Claudia Dreverman  
22/2 Rodborough Avenue,  
Crows Nest nSW  
3 April 2022

APPLICATION NAME: BOWDENS SILVER MINE AMENDMENT  
APPLICATION NUMBER: SSD5765  
**VISUAL IMPACTS**

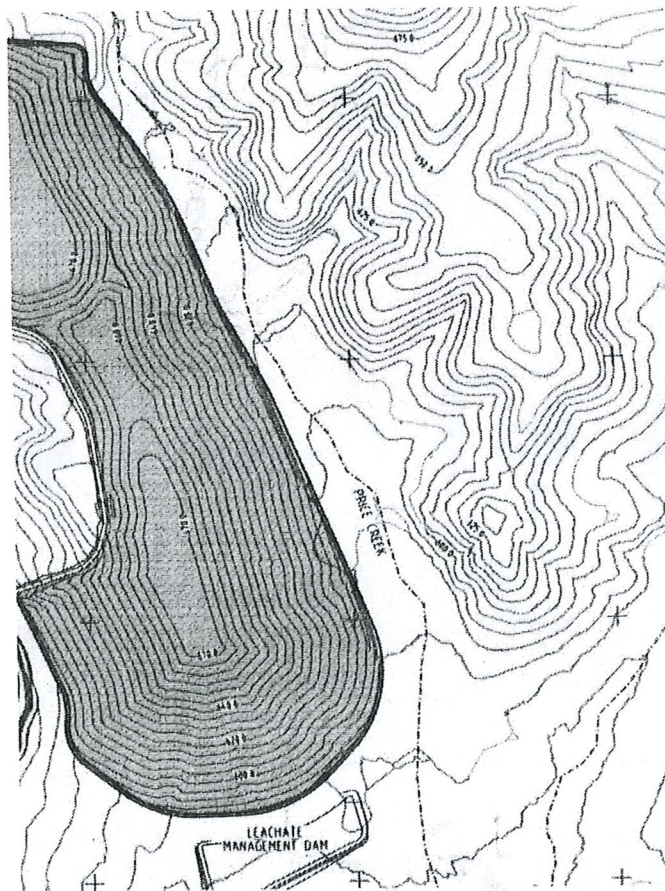
As I asserted a 100 metre high sand castle shaped pile of rocks is a negative outcome and should not be allowed. Is the reader of the proposal documents looking at drawings meant to conclude any different. Simply described the WRE is:

Over one Kilometre long

It is 100 metres high

It has slab or planar sides without any natural contour design (nothing like the hills behind it)

The slab sides are at a constant angle of about 25 degrees

The slab sides meet at a ridge (narrow with enough room for single vehicle track)

The ridge is near enough to horizontal (dead straight like a cottage roof or a railway siding grain shed.)...totally unnatural.

This is an appalling feature to foist onto our visual experience but Bowdens propose to leave it like that for ever. Look at it graphically this is a Bowdens map of the WRE.

The shaded mass is the WRE. All but for a tiny wiggle the contours are straight. They are also equally spaced...meaning constant slope. To the right (east) of Price Creek is natural landform. Chalk and Cheese. And furthermore those tiny wiggles are at such a scale invisible; they could simply appear as rough dozer work. It is time for some honesty about the proposal.
